Response to Planning Application

From: Arun District Council Greenspace

Application ref: WA/106/20/DOC

Description: Approval of details reserved by condition imposed under ref WA/22/15/OUT relating to Condition Nos 6 - materials & finishes, 10 - hard & soft landscaping, 11(a) - protection of retained trees, 12 - surface water drainage, 14 - maintenance & managements of SuDs, 15 - foul drainage and 20(d) - forecourt layout, drainage, position & intensity of lighting fitments.

Planting Area No. 8

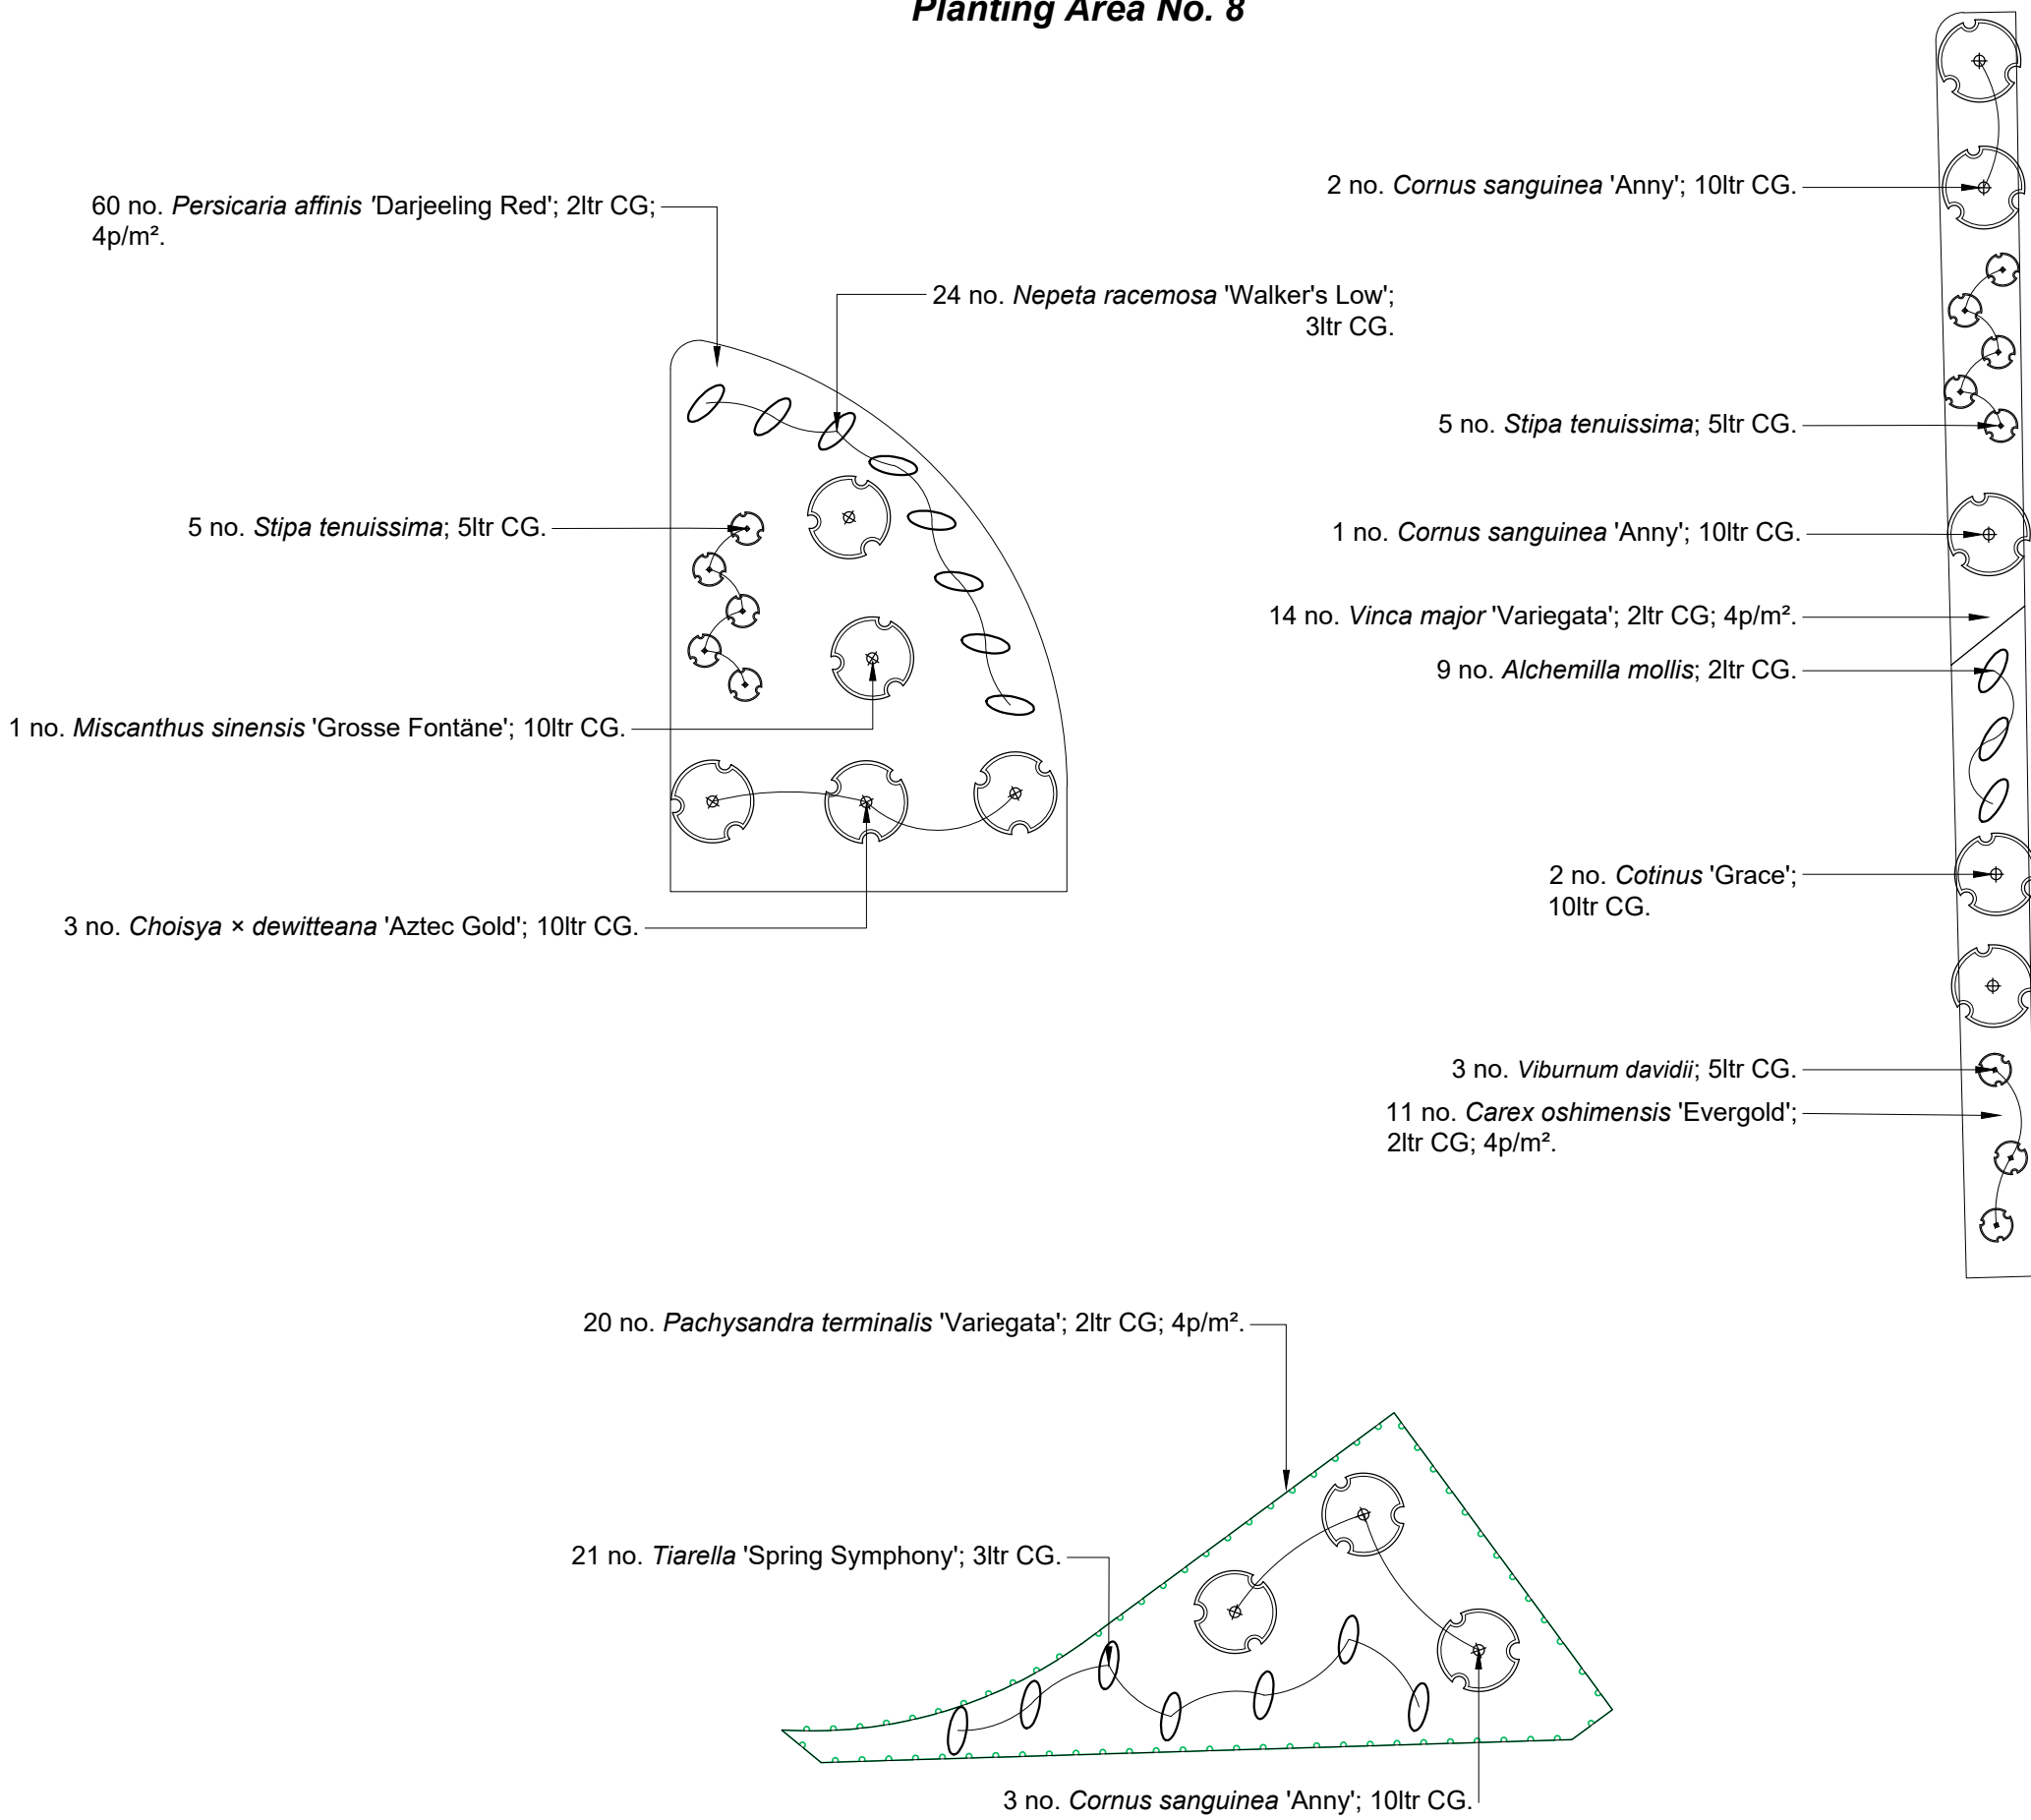
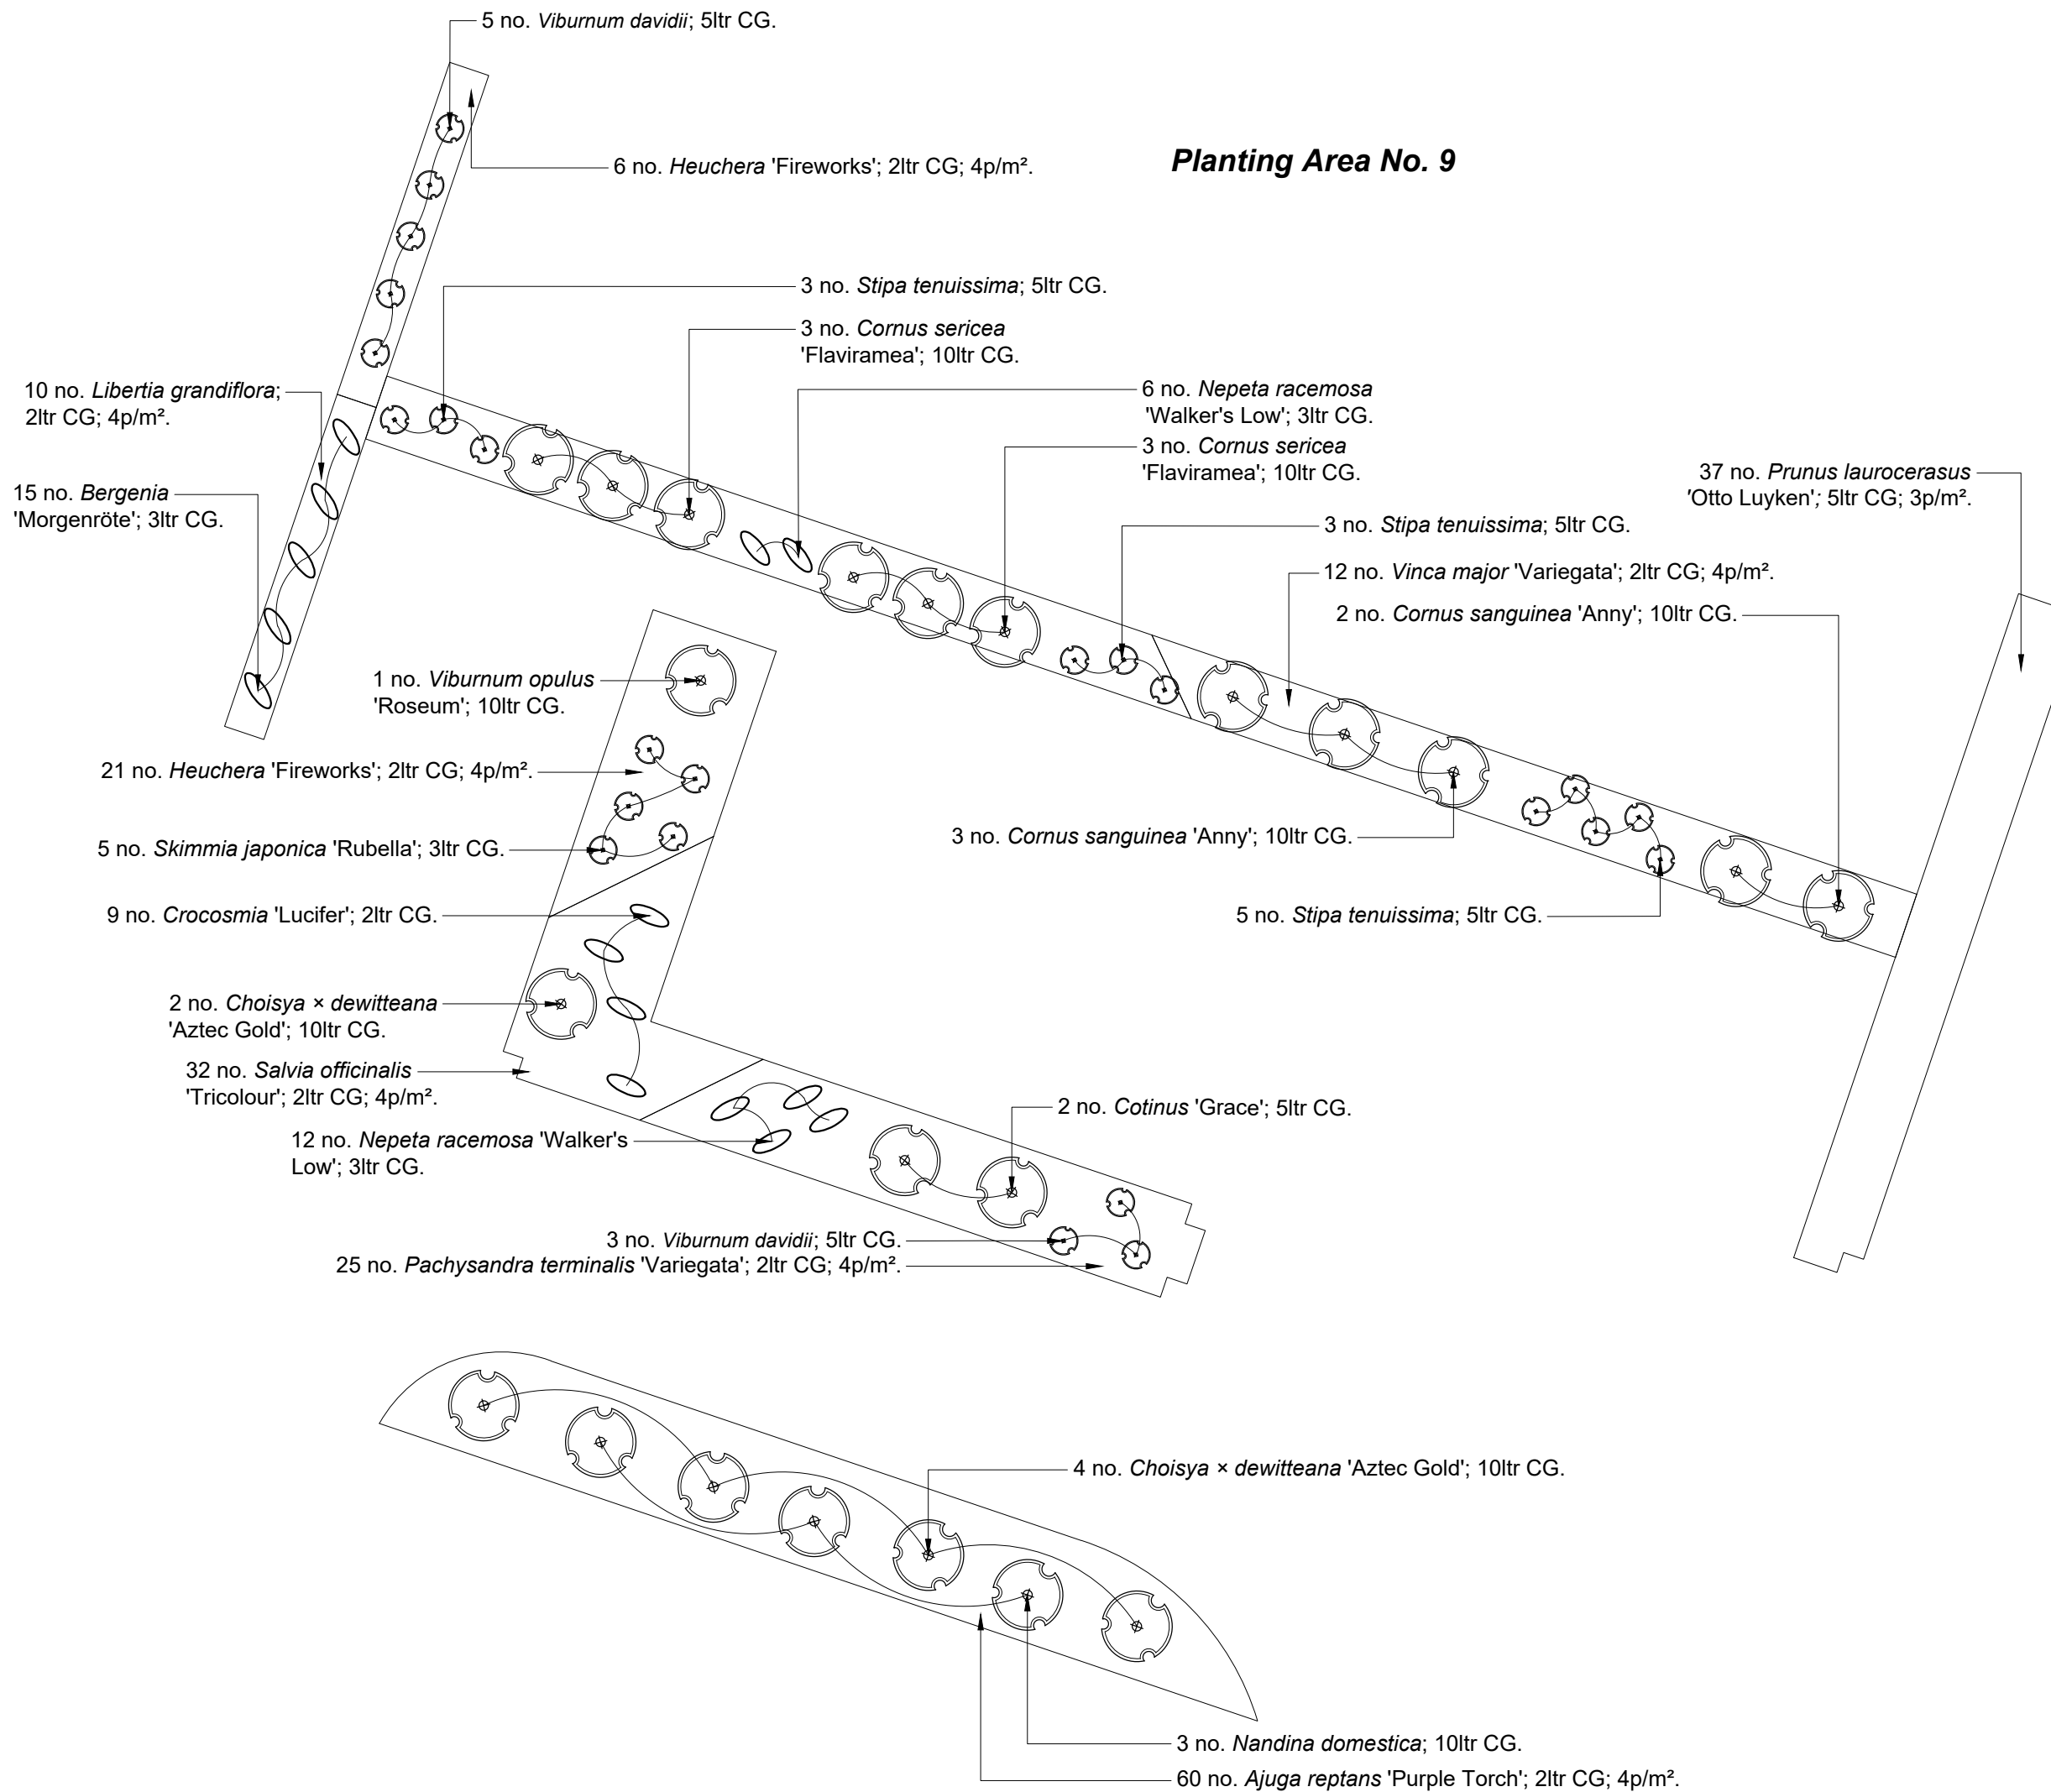
I can confirm that the proposals detail a scheme which would be suitable for location and fitting for this setting. The detail has included a good element of native mixed tree and hedge planting mixes which will aid in biodiversity gain and habitat formation. The scheme has also considered an ornamental element to the planting which would be suitable for the building, carparking and communal surrounds.
